A12 Widening Scheme Jn 19 to Jn25

My name is Charles Martin and I have submitted, in conjunction with the Boreham Conservation Society (Bill Kyle), several items to the ExA re Jn 20A.

I note recently that the Applicant is considering changes to the northbound slip road onto the A12 from Jn19.

Map Book 1: Junction 19 Slip Road

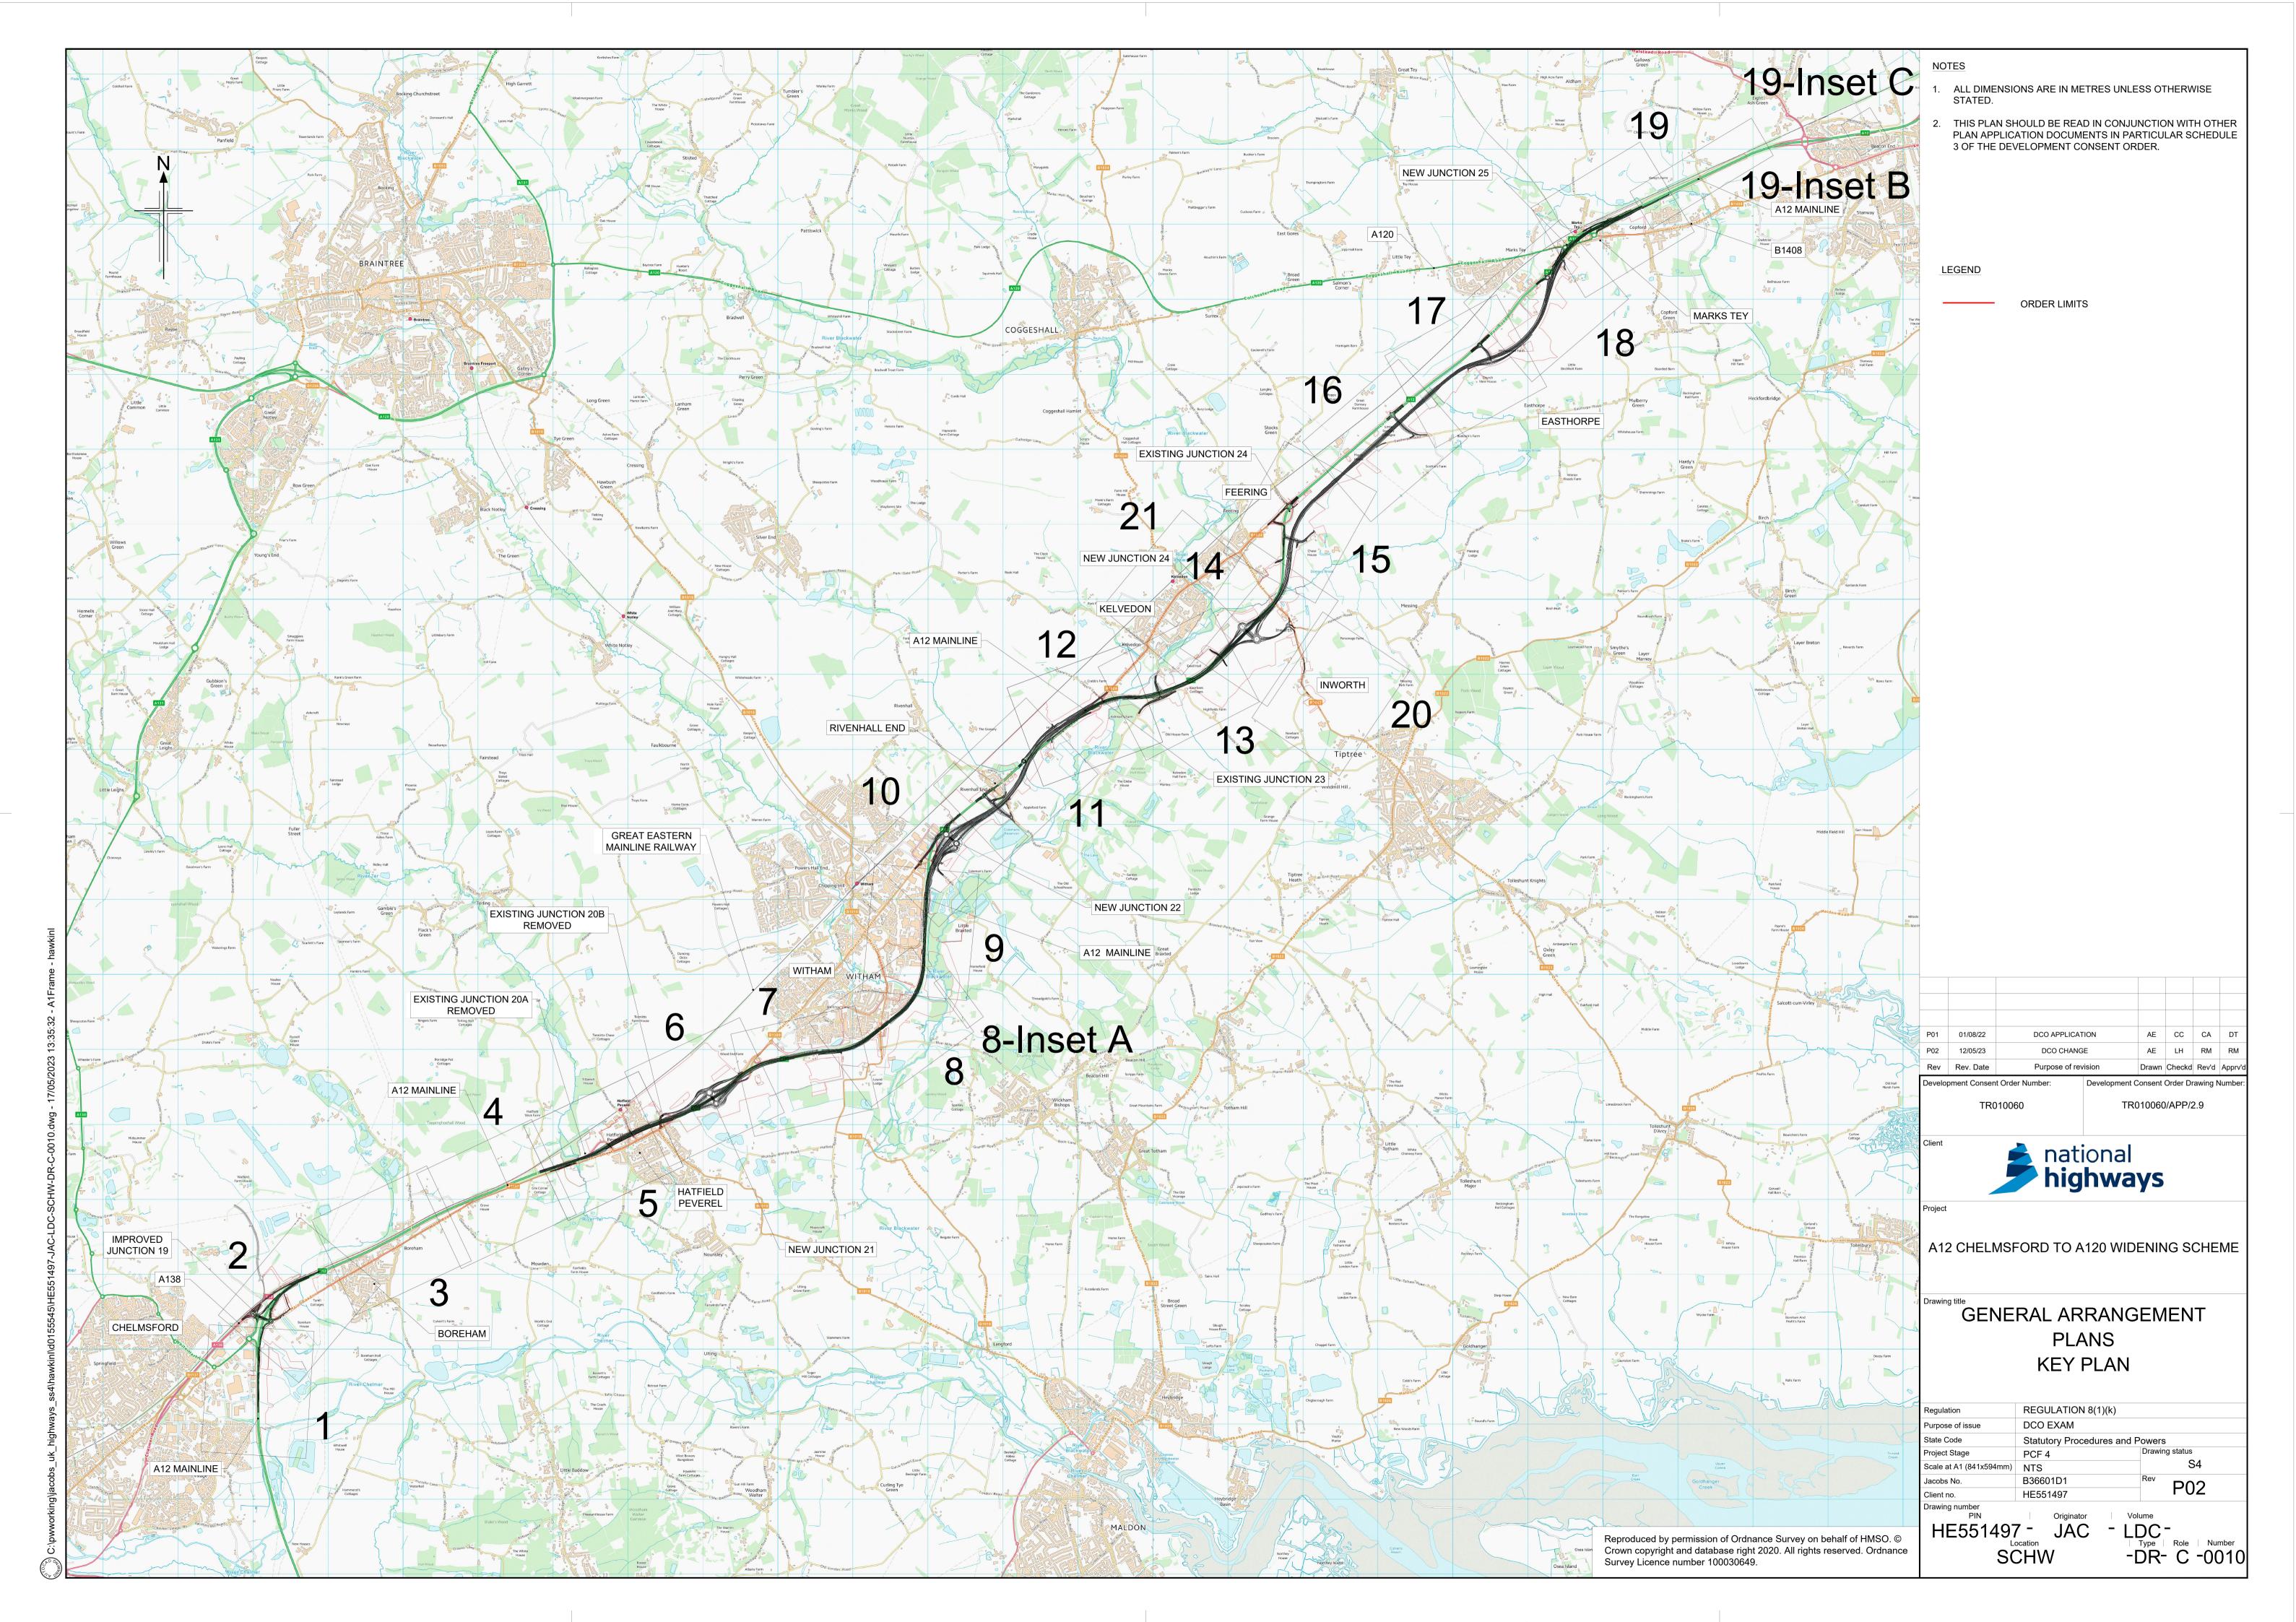
1. The Applicant has on many occasions argued that my proposal for retaining junction 20A southbound will produce problems for traffic entering the A12 southbound from the proposed Jn21 clashing with traffic entering southbound from my proposed Jn20A due to the weaving lengths between the end of the jn21 merge and the jn20A nosing being too short. I estimate this weaving length is somewhere between 1000m to 1200m.

With the Applicant's revised proposal for the Jn19 slip northbound, I estimate that the distance between the proposed northbound merge and the existing slip nosing will be some 250m to 350m.

I fail to see how the Applicant's argument re the weaving length being too short for the area around Hatfield Peverel between Jn. 21 and my proposed 20A is valid and I request that this argument is ignored.

2. The Applicant's initially submitted proposal to merge the two northbound slip roads from Jn19 into one before entering the A12 main line indicated that Beaulieu Bridge traffic wishing the travel onto the A12 northbound would have a dedicated left only slip avoiding the Generals Roundabout signalised junction. If this idea is now to be abandoned, how will traffic enter the A12 northbound from Beaulieu in the interim period between the completion of Beaulieu Bridge/ Radial Relief Road. If the proposal is to make this traffic wait at the roundabout signals, circulate around the roundabout and enter the existing northbound slip onto the A12; I can see this will create some unforeseen capacity problems on the Generals Roundabout. This needs to be assessed in detail to ensure that no capacity reduction is produced. We have waited long enough for the Beaulieu Radial Relief Road and Jn19 capacity improvements to come on stream and we do not wish to see this improvement eroded almost immediately.
